**WELWYN HATFIELD COUNCIL – DEVELOPMENT CONTROL**  
**DELEGATED REPORT**

<b>APPLICATION No:</b>	<b>S6/2008/2412/FP</b>
------------------------	------------------------

This application seeks full planning permission for erection of part two storey rear extension, first floor bay window and replacement garage to the side and front of the existing house.

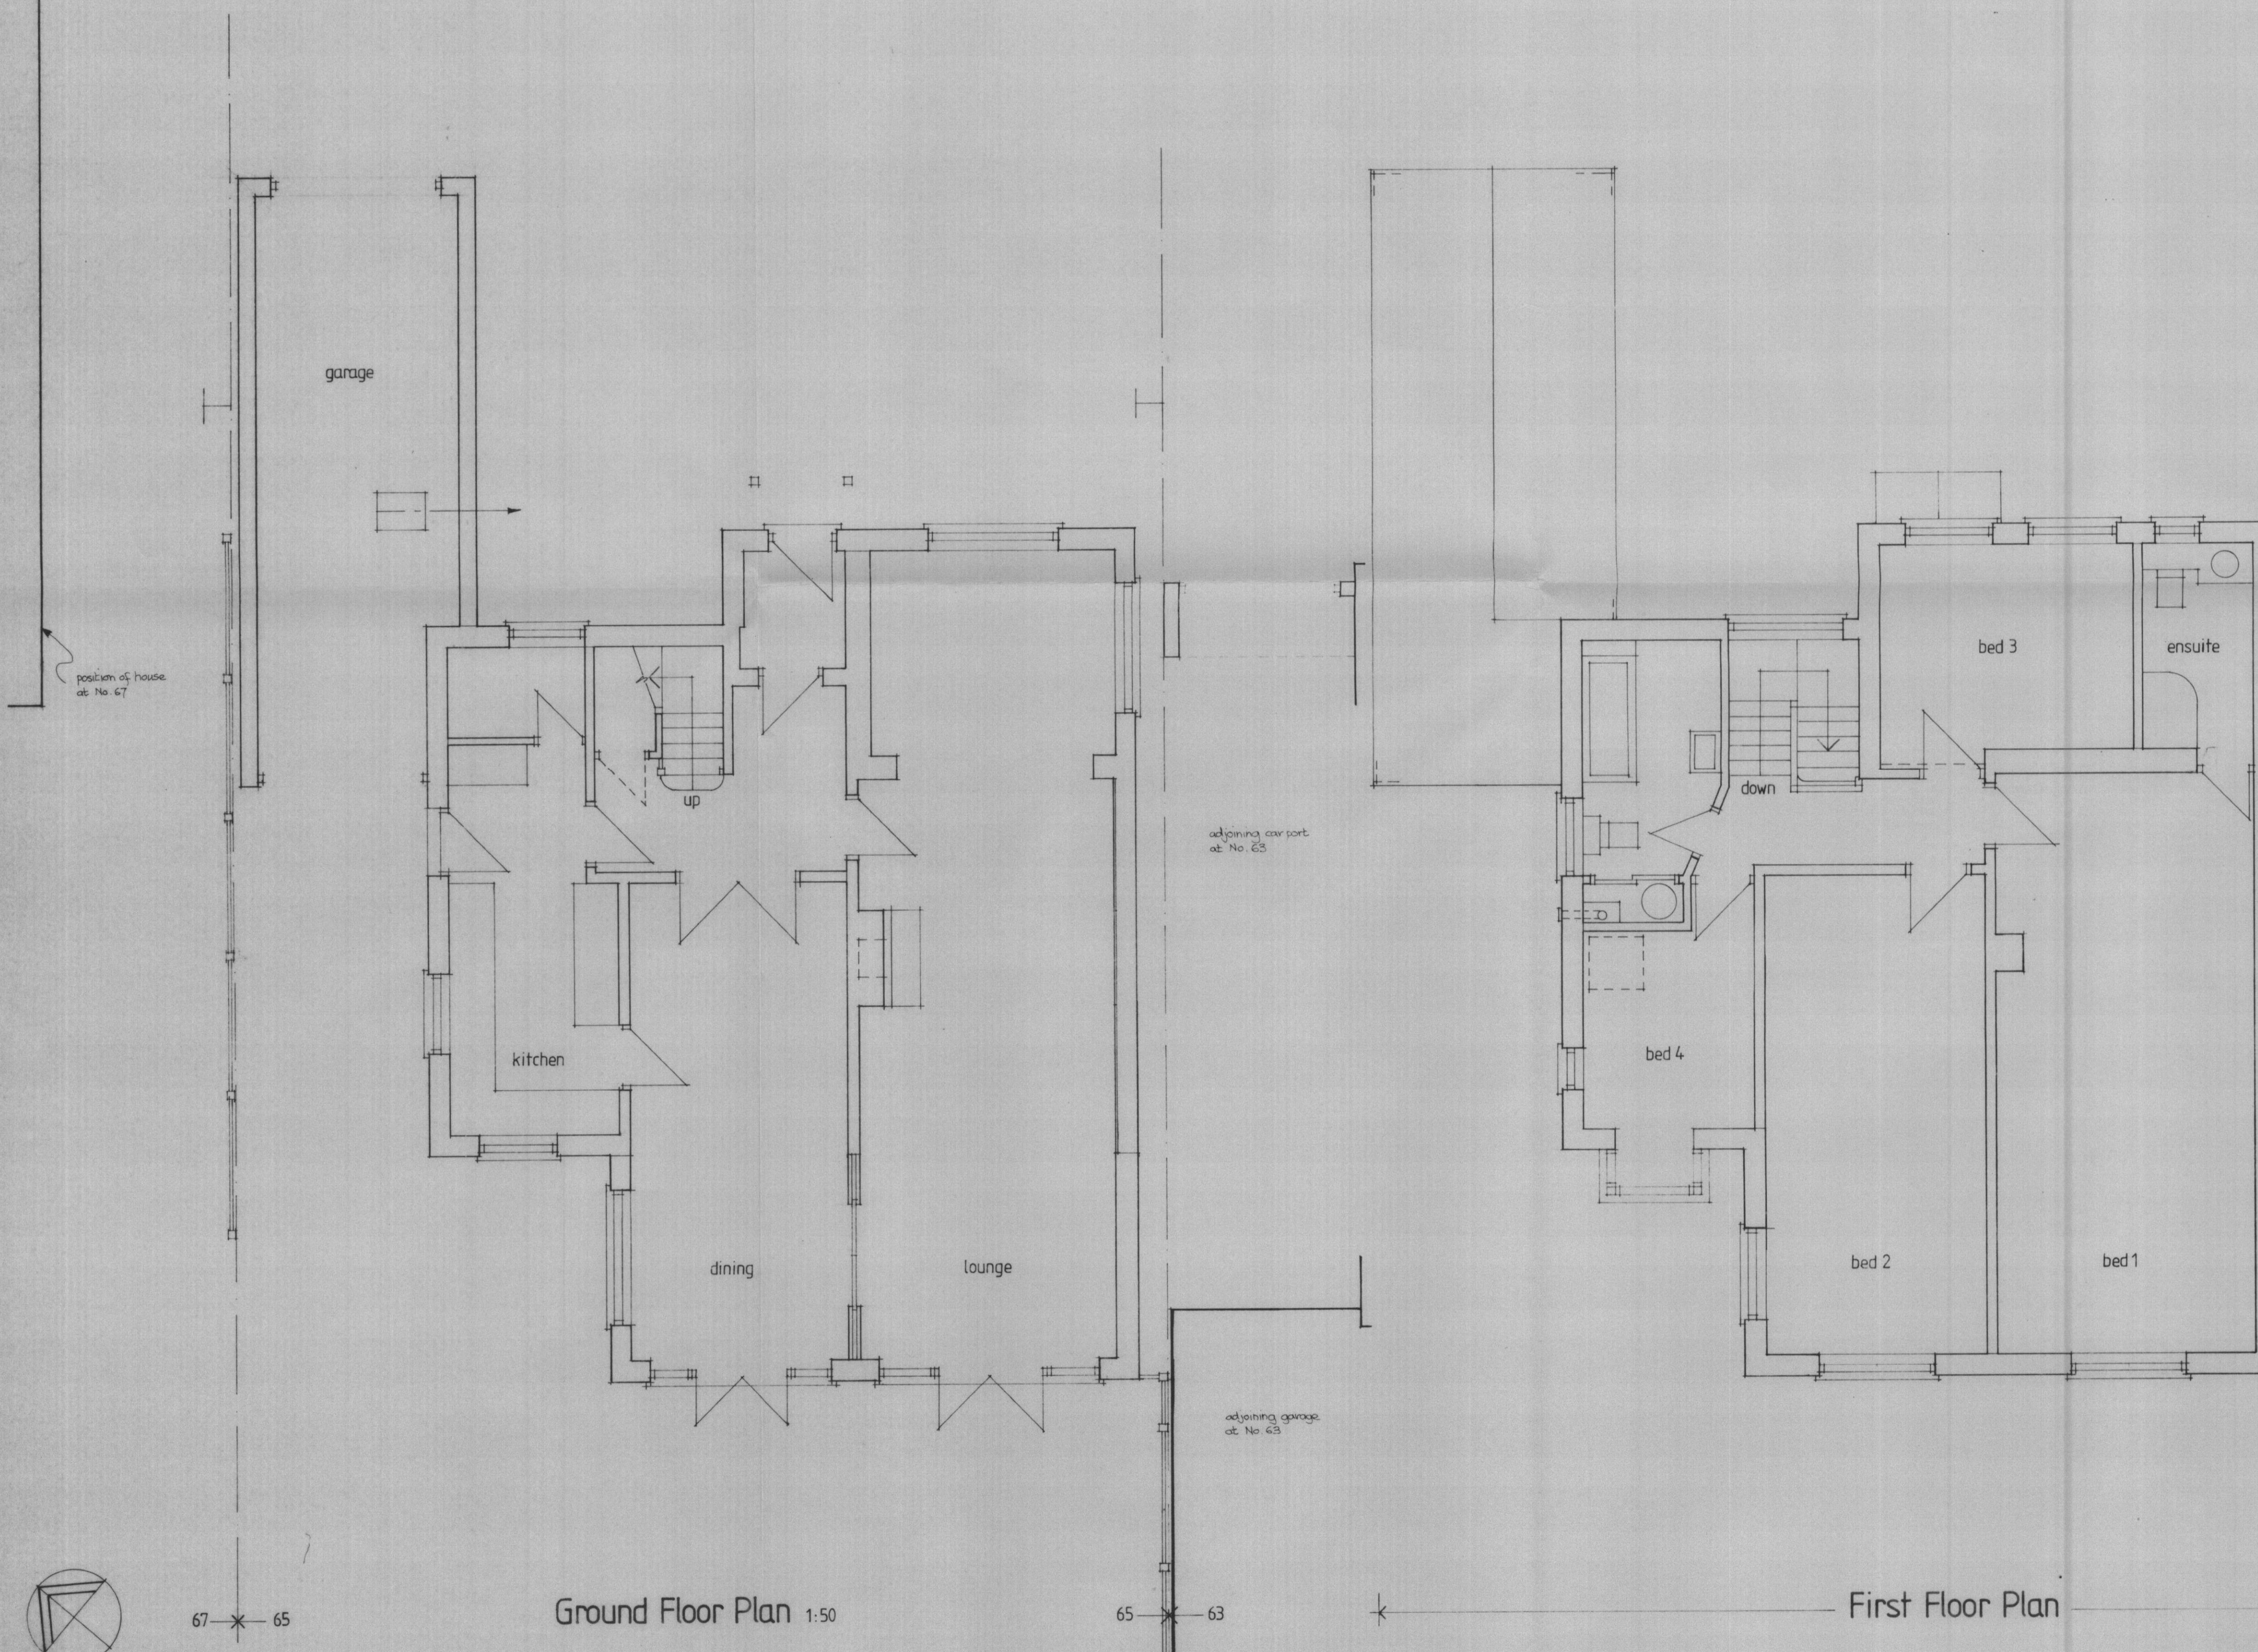
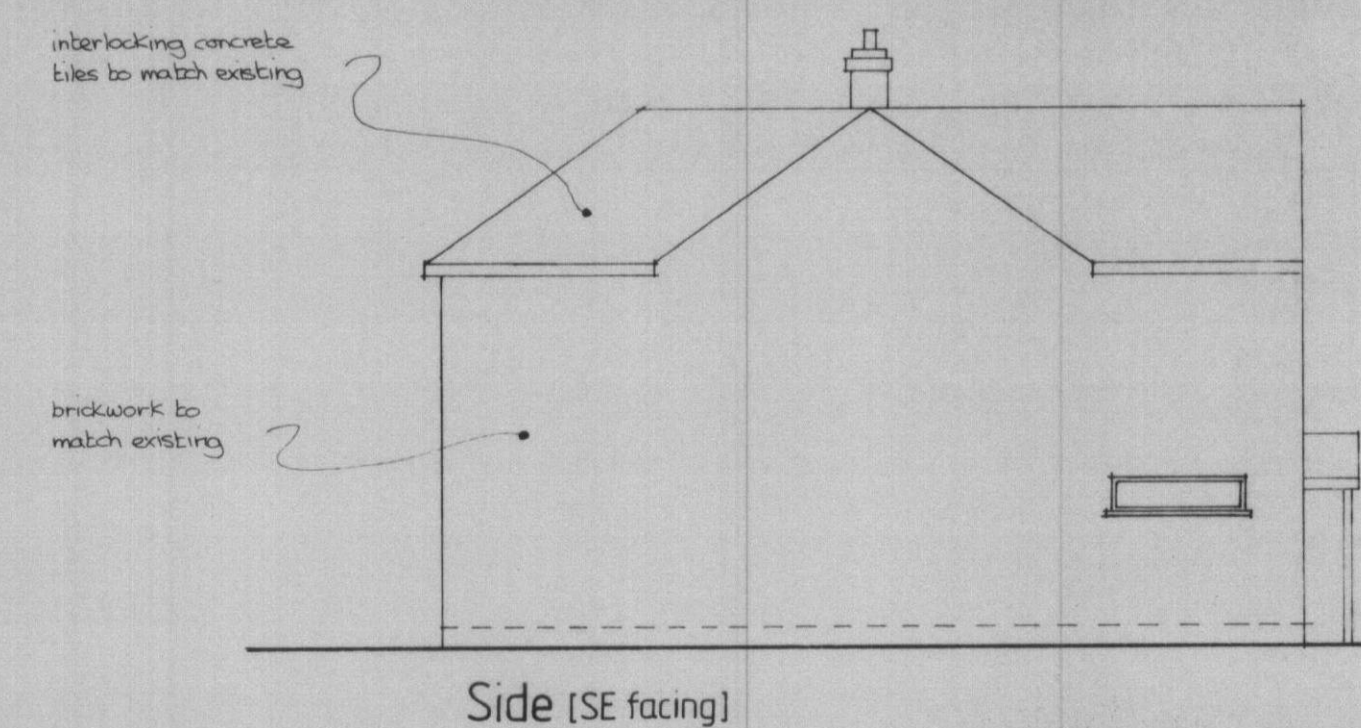
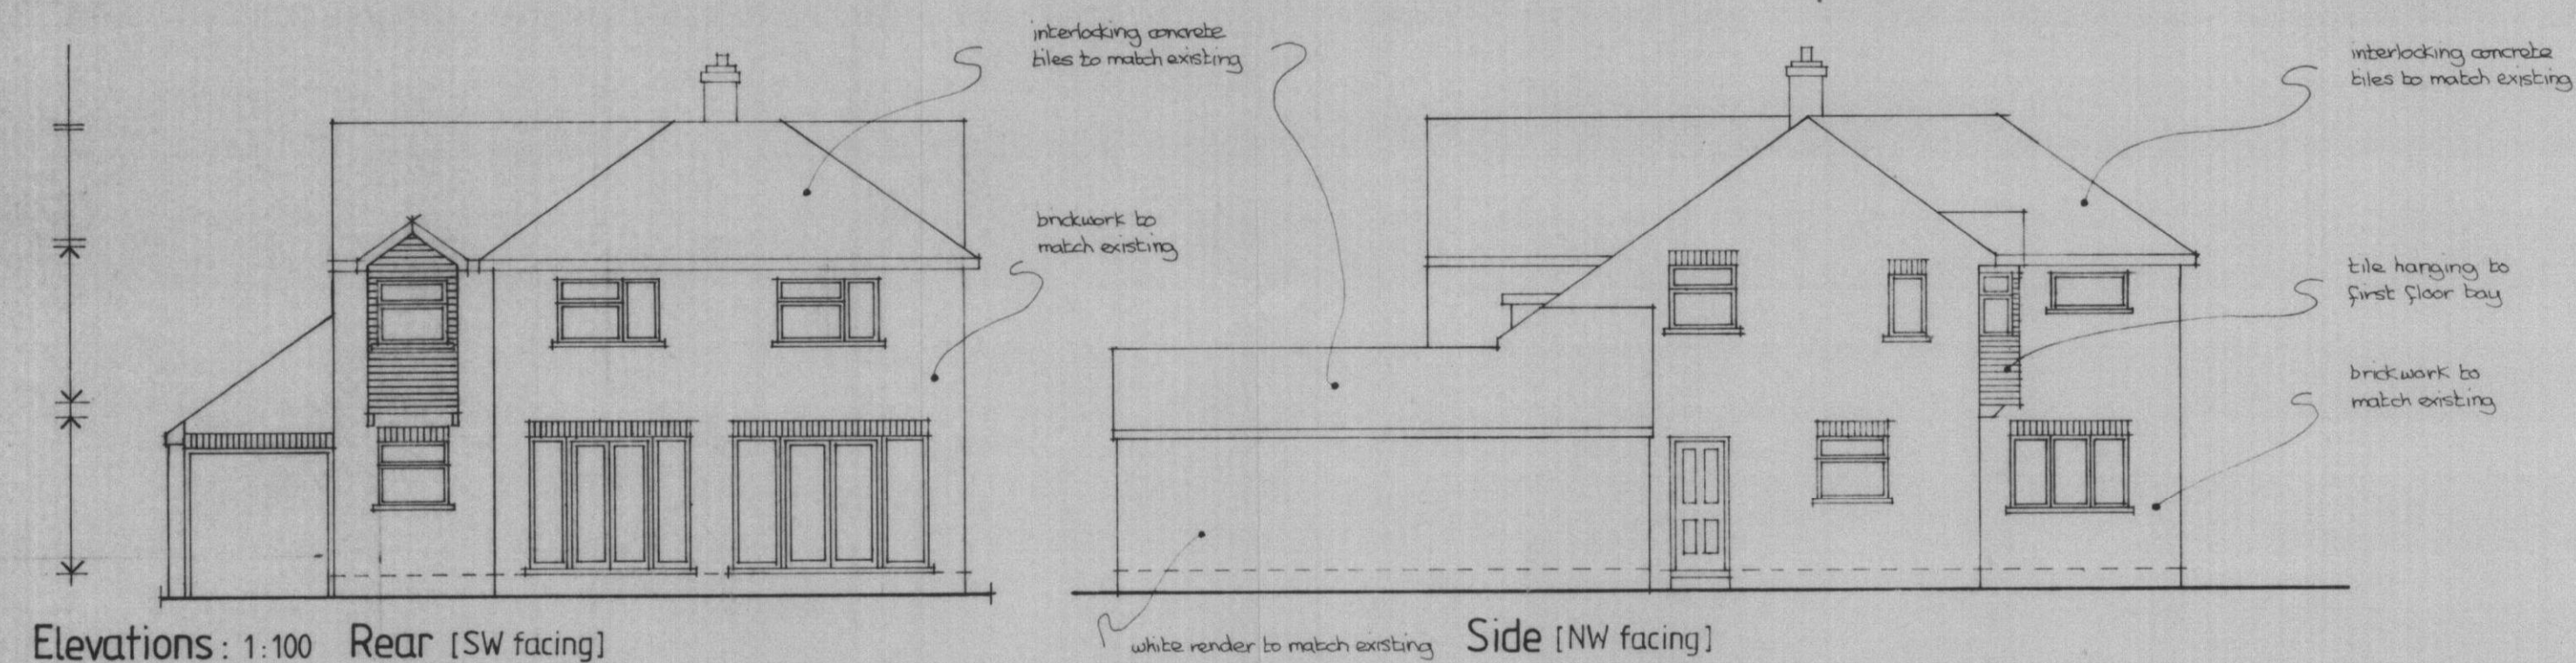
North Mymms Parish Council did not object but commented that the forward projecting garage would appear to be out of keeping with street scene.

Although the Council would generally discourage a garage or front extension which projects to the extent proposed, the impact in this particular case is reduced by the virtue of the adjacent dwelling No.67 Pine Grove being positioned approximately 8m forward of the application dwelling. Moreover approximately 15.5m separation distance from the highway would be maintained.

The design of the rear extension would not have an adverse visual impact upon the character and appearance of the existing dwelling or the streetscene. The flank wall of the proposed two storey rear extension would be nearer to the site boundary than the minimum requirement of 1m as outlined in Supplementary Planning Guidance. However, existing spacing within the streetscene would be maintained as the proposed extension would be in line with the existing flank elevation and would not be visible from the street. The extension would be constructed of materials that are in keeping with the existing dwelling and the character of the area. The proposals comply with PPS1 Delivering Sustainable Development, Policy SS1 and ENV7 of the East of England Plan 2008 and Policies D1 and D2 of the Welwyn Hatfield District Plan 2005 and Supplementary Design Guidance 2005 (Statement of Council Policy).

No.63 Pine Grove features an existing two storey rear extension which projects to a similar extent as the extension proposed at No.65. As a result the proposed two storey rear extension would not have an overbearing impact on the occupiers of No.63, neither would it have a detrimental impact upon the privacy or light amenity currently enjoyed by occupiers of this dwelling. The proposed extension would not result in unacceptable loss of amenity to No.67 Pine Grove due to adequate separation distances between the proposed extension and the site boundary. The windows proposed in the north flank elevation and the side window within the proposed first floor bay would be fixed and obscure glazed by way of planning condition. No letters of representation were received from occupiers of neighbouring dwellings. The proposals are therefore in accordance with Policy D1 of the Welwyn Hatfield District Plan 2005 and Supplementary Design Guidance 2005 (Statement of Council Policy).
